Reference no. 2021/CL/93051/W

Site Address	Fieldhouse Lane, Huddersfield, HD1 1AG
---------------------	---

Description	Prior approval for alterations to railway bridge under Part 18(a), Schedule 2 of the Town and Country Planning (General Permitted Development) (England) Order 2015
--------------------	--

Officer Report

Proposed: Field House (MVL3/98) Elevation A-A

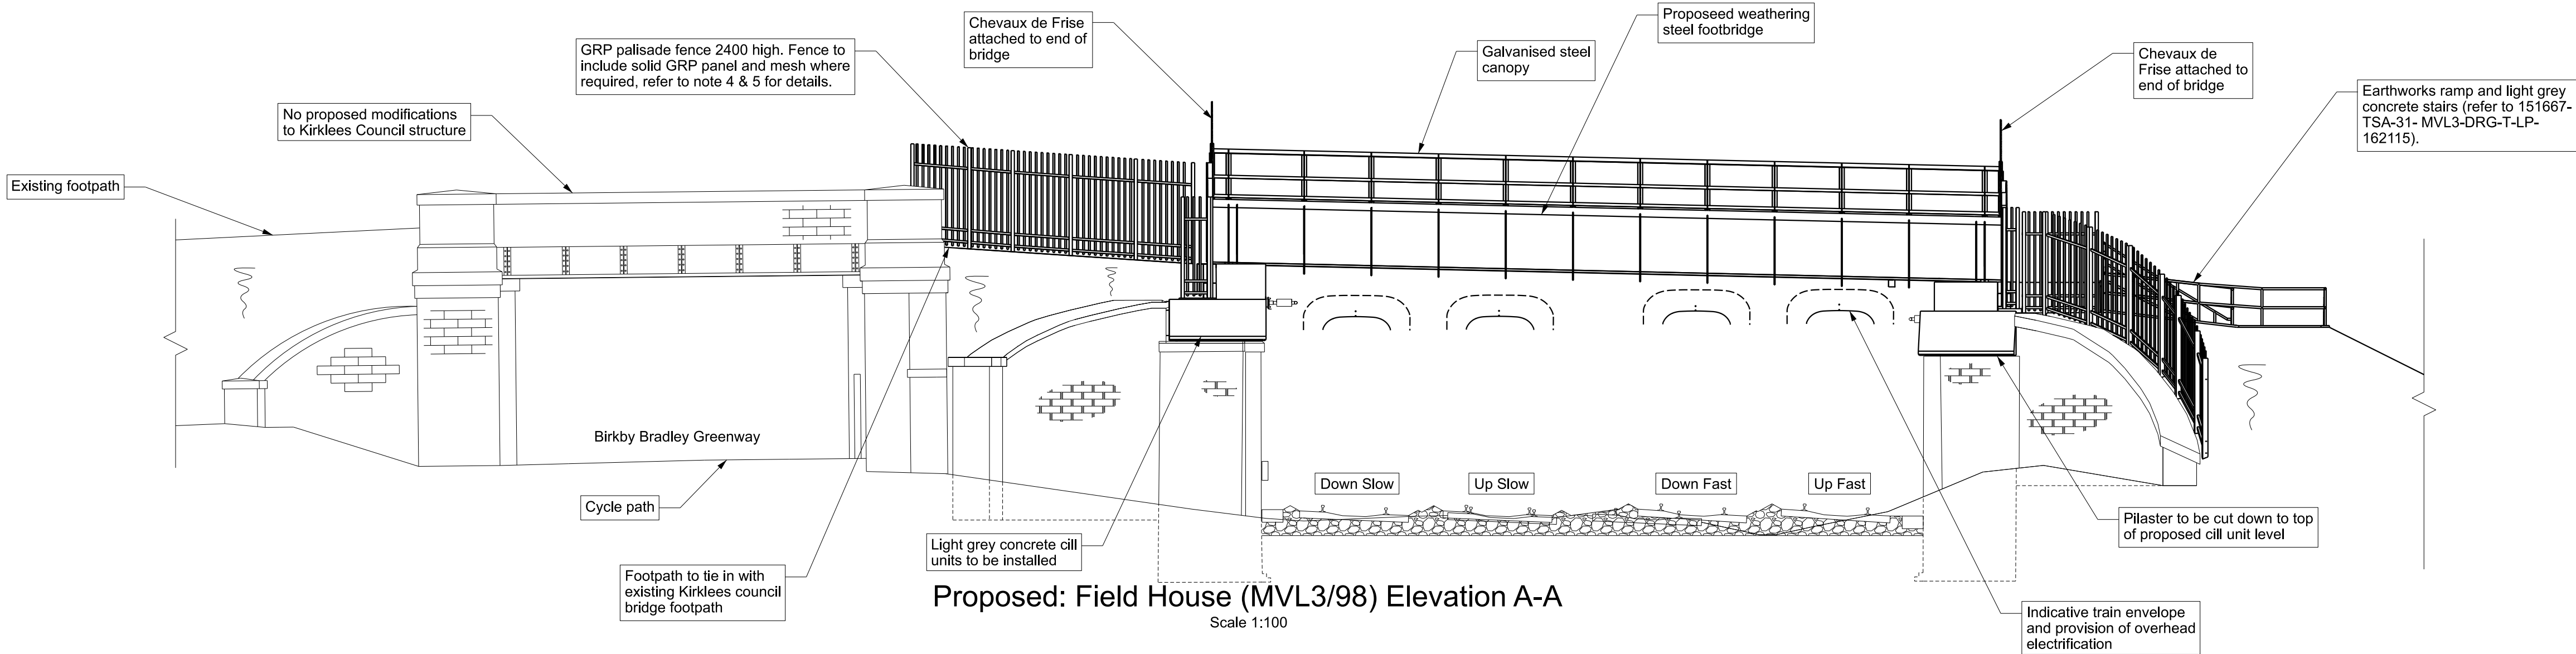
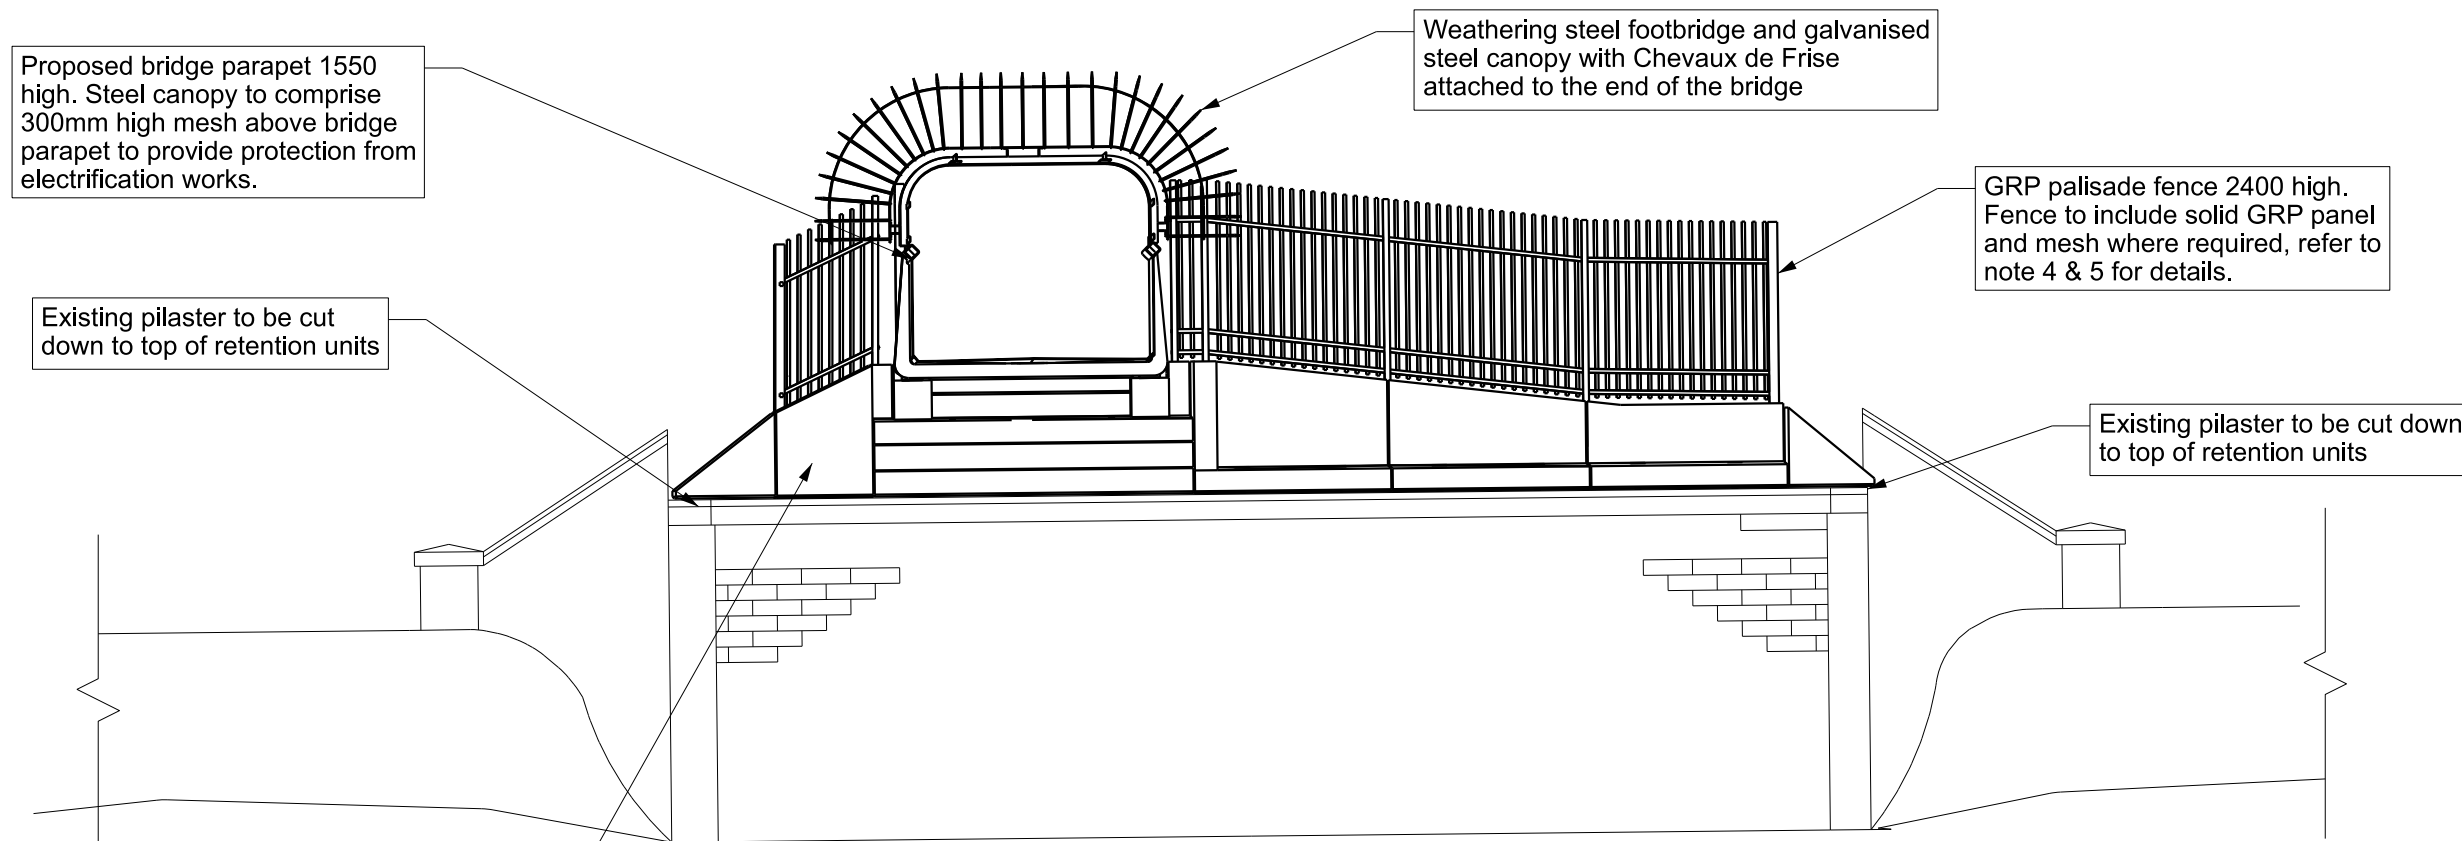
- i. CI document (page 2, Elevation A-A) cites "Combined non-slip waterproofing and surfacing to bridge deck plates..."
response: acceptable
- ii. CI document also cites "note 15" in the same annotation as above, but there is no further detail.
response: Note 15 is deleted from consideration
- iii. The surfacing material of the steps is cited as 6mm thick GRP tread with nosing.
response: This shall be in a non-slip finish
- iv. CI document (page 3, Section E-E) cites unreinforced concrete with a brushed finish to the "dog-leg" ramp, which contradicts drawing no 151667-TSA-31-MVL3-DRG-T-LP-162115, submitted with the original prior approval which shows a granular construction ("Section C-C" and "Typical section through ramp").
Response: The dog-leg ramp shall be in a concrete finish as cited in the Construction Information.
